Cockle Bay Park – Response to Agency Submissions

21 June - 2pm

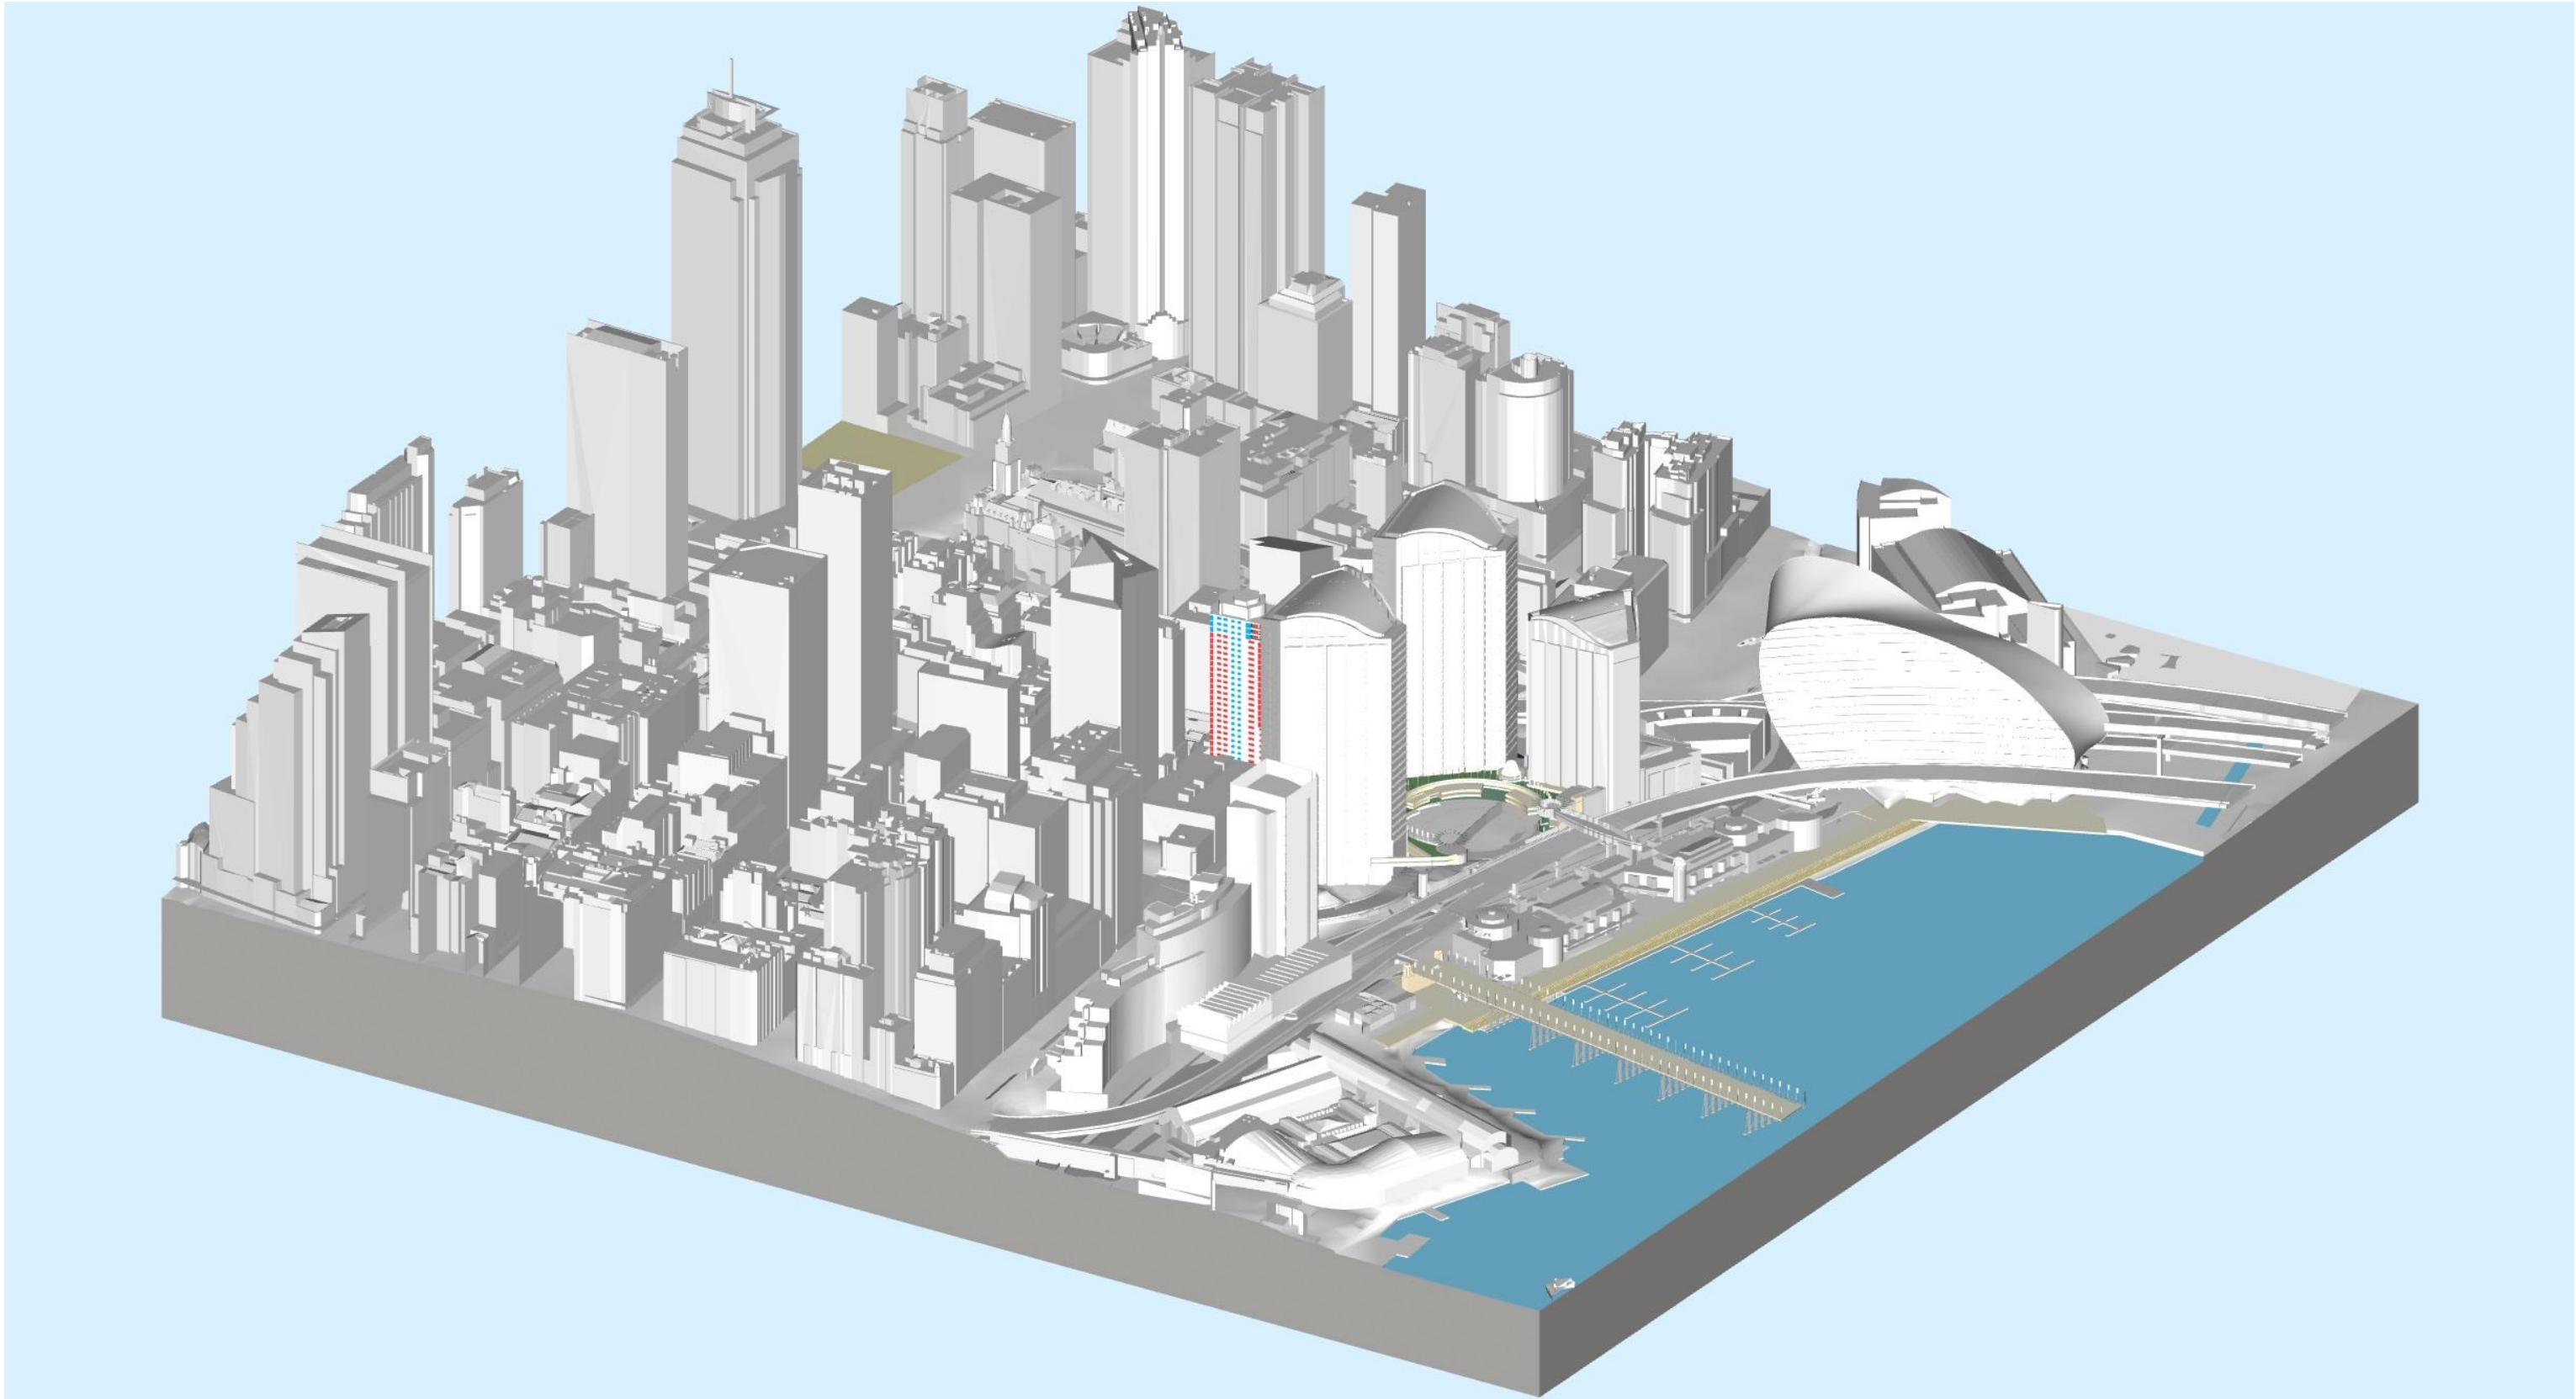
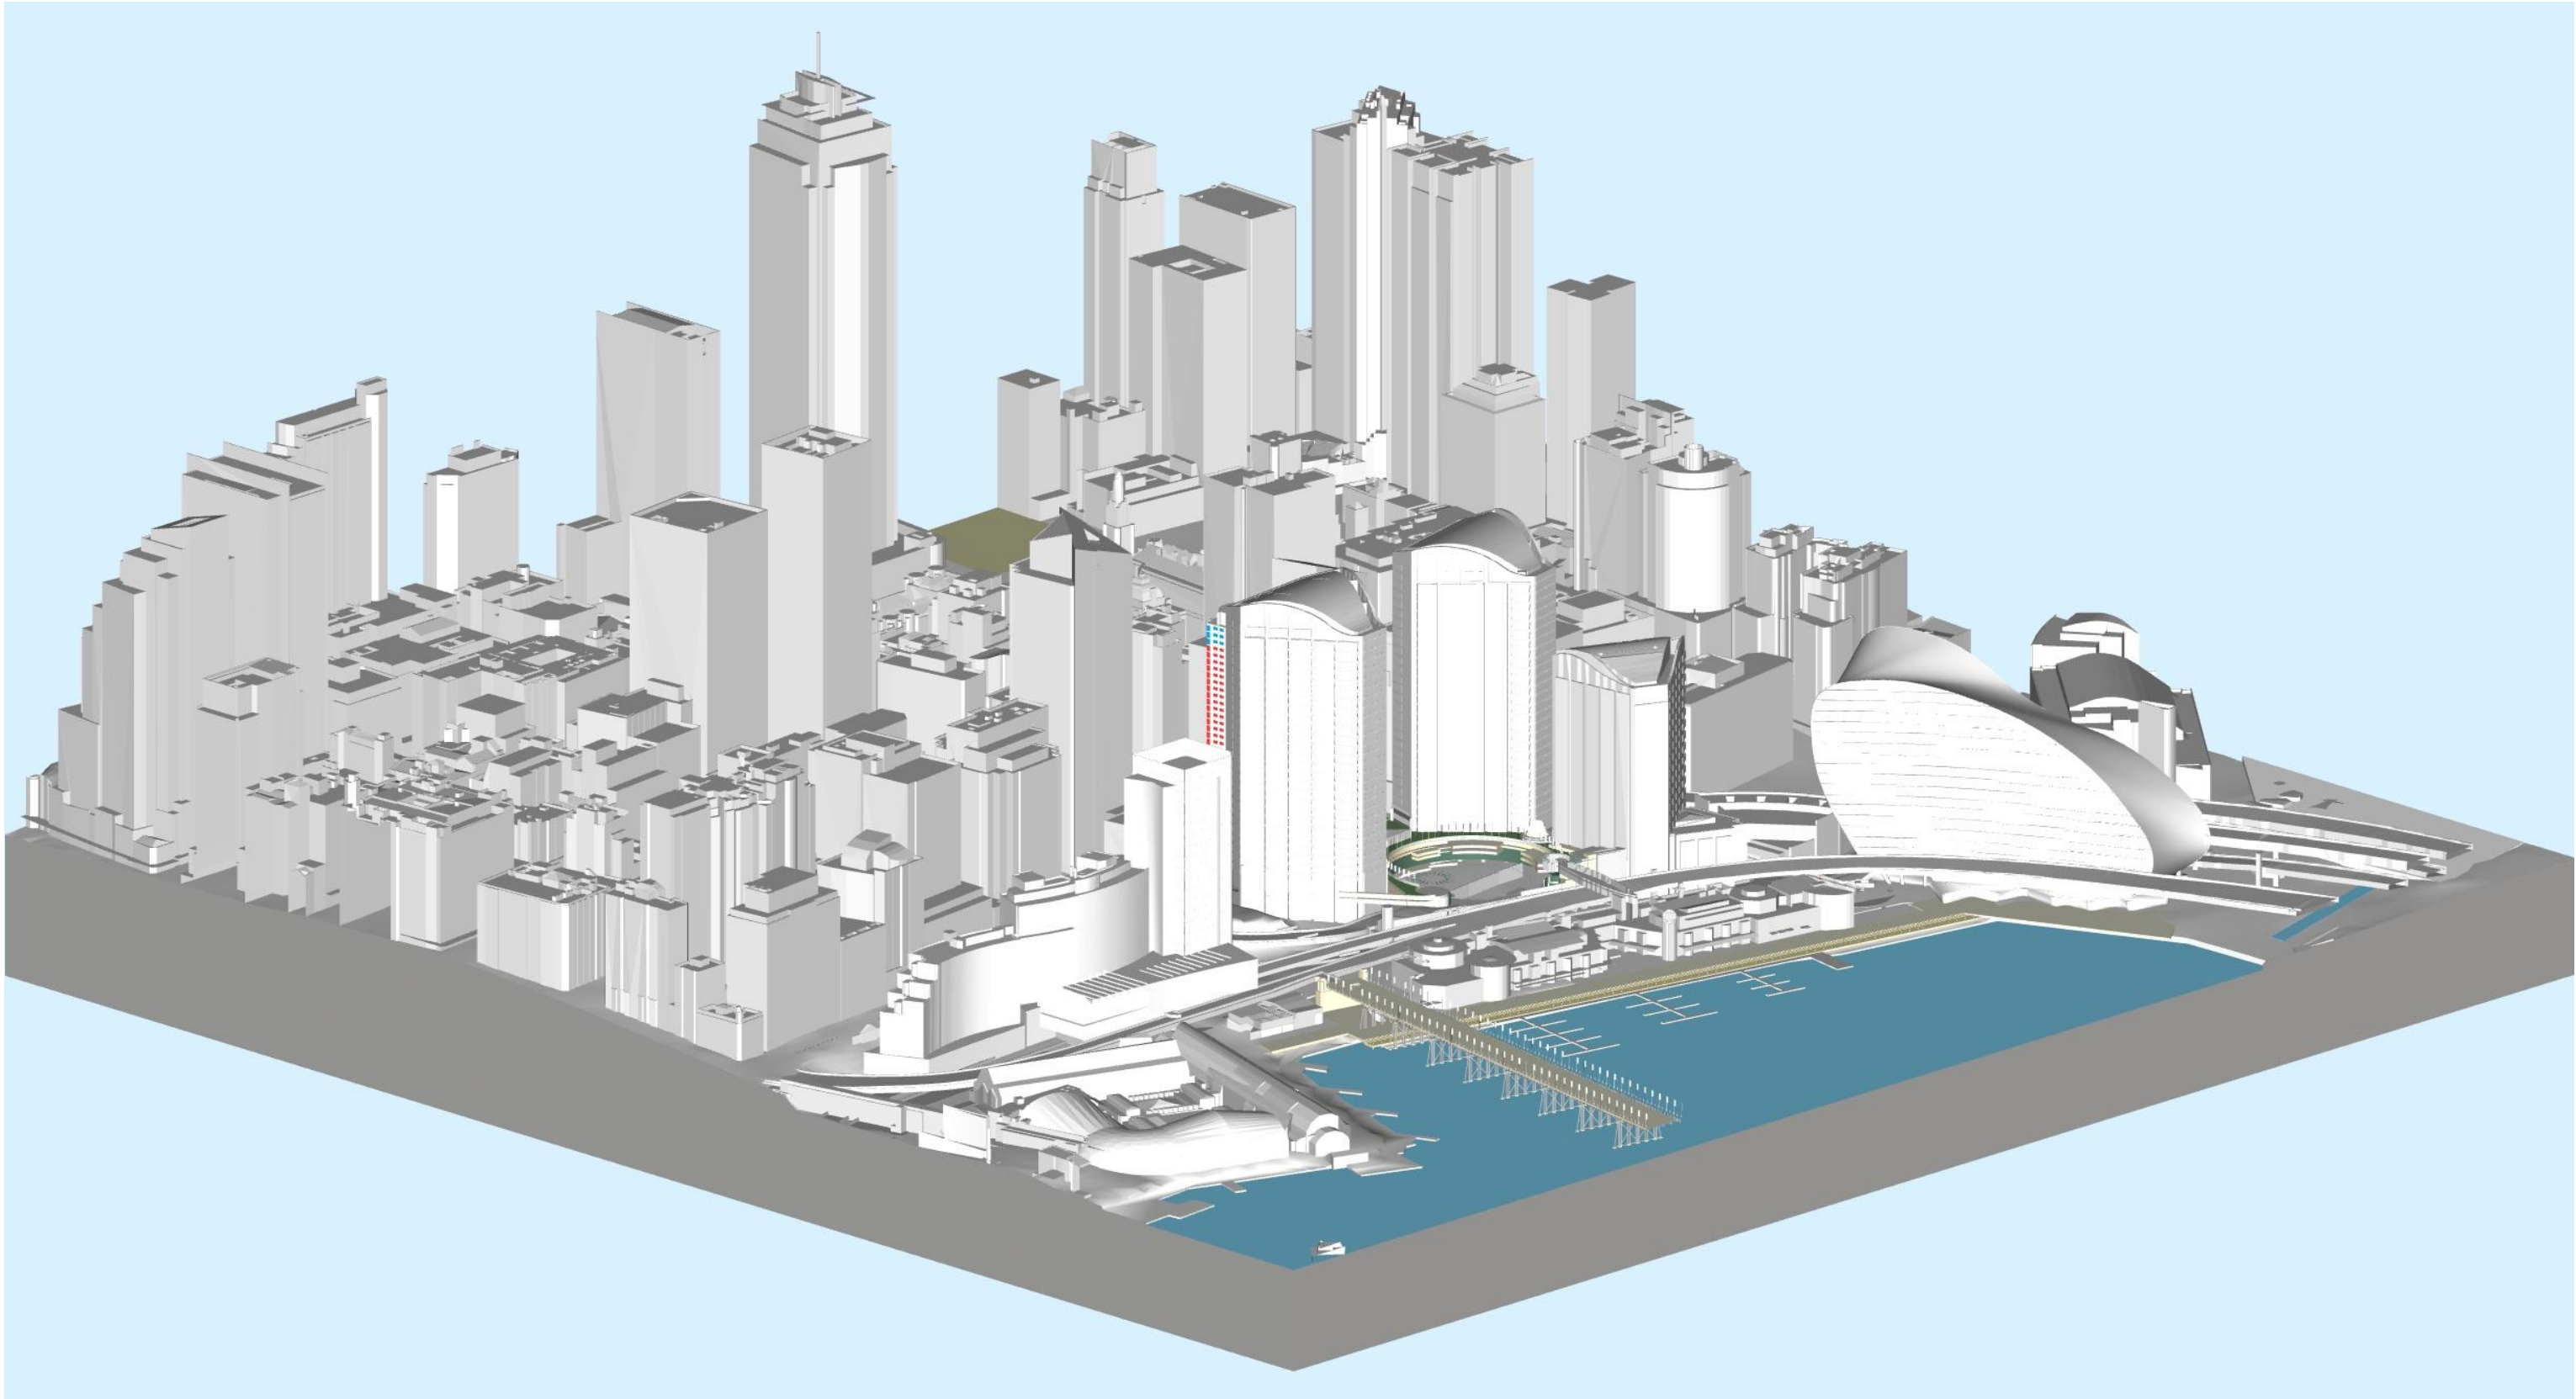
<i>Overshadowing</i>	
<p>Tumbalong Park will be impacted by overshadowing from the proposed development</p>	<p>One of the design principles of the Cockle Bay redevelopment is to avoid mid-winter overshadowing of the public domain areas of Tumbalong Park and the Children's playground. This principle is based on the precedent set by the Ribbon development approval.</p> <p>Two sun planes define the top of the proposed envelope, one at 12:00pm and one at 11:00am. The planes</p>

Item Raised	Proponent's Response
	<p>are generated from the roof line of the Ribbon development and project northward.</p> <p>To verify the sun planes solar studies and solar access analysis were undertaken. These studies demonstrate that the proposed development <u>does not generate any additional mid-winter overshadowing of Tumblong Park and the children's playground.</u></p> <p>Refer to the Solar Access Study included as part of Appendix C.</p>
<p>The proposed Town Hall Square will be impacted by overshadowing from the proposed development. The northern and eastern parts of the Town Hall Square will be most affected. The impacted times of the year will be from the beginning of April to late April and from mid-August to mid-September. During these times, the north-east corner will lose up to 25% of its direct afternoon sun.</p>	<p>Since the exhibition of the EIS the Concept Proposal has been further reduced and in-turn has reduced the amount of overshadowing predicted to affect the future town hall square. Updated shadow diagrams have been prepared that delineate between a shadow from the envelope and a shadow by a possible building within that envelope to understand overshadowing. The diagrams show there would be only minor additional shadowing to Town Hall Square that would be more than offset by increased provision of open space facilitated by the amended Concept Proposal.</p> <p>The Solar Access Study prepared by FJMT and included as part of Appendix C has compared the shadow impact to Town Hall Square from the original EIS and the amended Concept Proposal which shows there is an improvement (from 21 hours to 11 reduction) in sunlight over the course of the year.</p> <p>It is acknowledged that the amended Concept Proposal results in the potential for minimal overshadowing of the Square. Notwithstanding, the potential minimal overshadowing is considered reasonable in the circumstances for the following reasons:</p> <ul style="list-style-type: none"> • The draft Central Sydney Planning Strategy proposes to introduce additional “no additional overshadowing” control to the future Town Hall Square between 12pm and sunset (year-round). The draft CSPS has not yet been publicly exhibited and is therefore not a matter for consideration under S79C of the EP&A Act. • The period of impact is limited to approximately 3 weeks just after the autumn equinox and just before the spring equinox, for a period of 15 minutes (reduced from 20 minutes) with the maximum overshadowing impact (increase of overshadowing to the square) on the most affected days being 1.5 % (reduced from 2.9%), reducing to zero on other affected days.
